An Coimisiún Pleanála

Third-Party Planning Appeal

Planning Authority:	Dún Laoghaire-Rathdown County Council
Planning Authority Reference:	LRD26A/0051/WEB
Decision Order:	P/1527/26
Date of Decision:	28th. July 2026
Appellant:	Carolyn Gregg
Address:	28 St. Vincent's Park, Temple Hill, Blackrock A94 FH72
Acknowledgement of	
Receipt of Submission:	4th. March 2026
Residential area principally affected:	St Vincent's Park, Blackrock

This is a third-party appeal against the decision of Dún Laoghaire-Rathdown County Council to grant permission under planning reference LRD26A/0051/WEB for the proposed development at the St Teresa's site, Temple Hill/Temple Road, Blackrock.

Figure 13.29 – Proposed south east elevation of Block D1

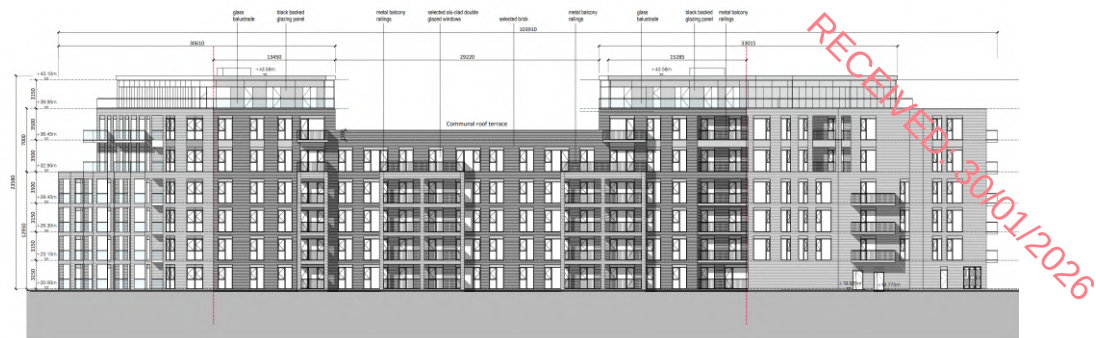
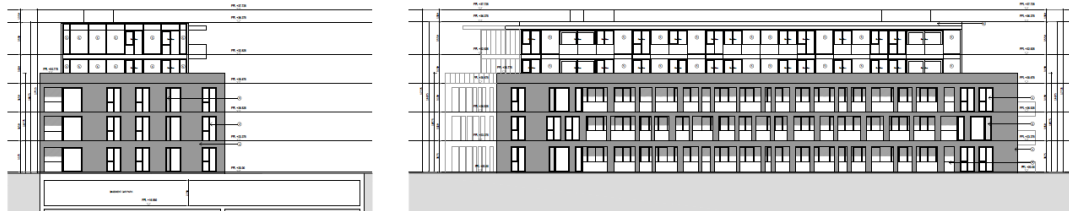
The evidence considered across this appeal should not be viewed in isolation. D1 is materially larger and taller than the previously permitted building; B4 remains at an interface that has repeatedly attracted planning concern; the current Planning Officer's Report acknowledges additional overshadowing of development in St. Vincent's Park; mature vegetation and landscape buffering altered and lost; and traffic/access matters remain subject to further requirements and conditions.

If the Commission is minded to grant permission, I respectfully request that it requires material amendments sufficient to address the grounds of appeal. In particular, the upper levels and/or overall massing of D1 should be reduced and/or further set back from St. Vincent's Park to provide a clear and durable step down towards the established low-rise residential area. The Commission should also ensure that where appropriate, any traffic/access, landscaping, lighting, noise or management measures on which the acceptability of the development depends are precise, enforceable and secured before occupation.
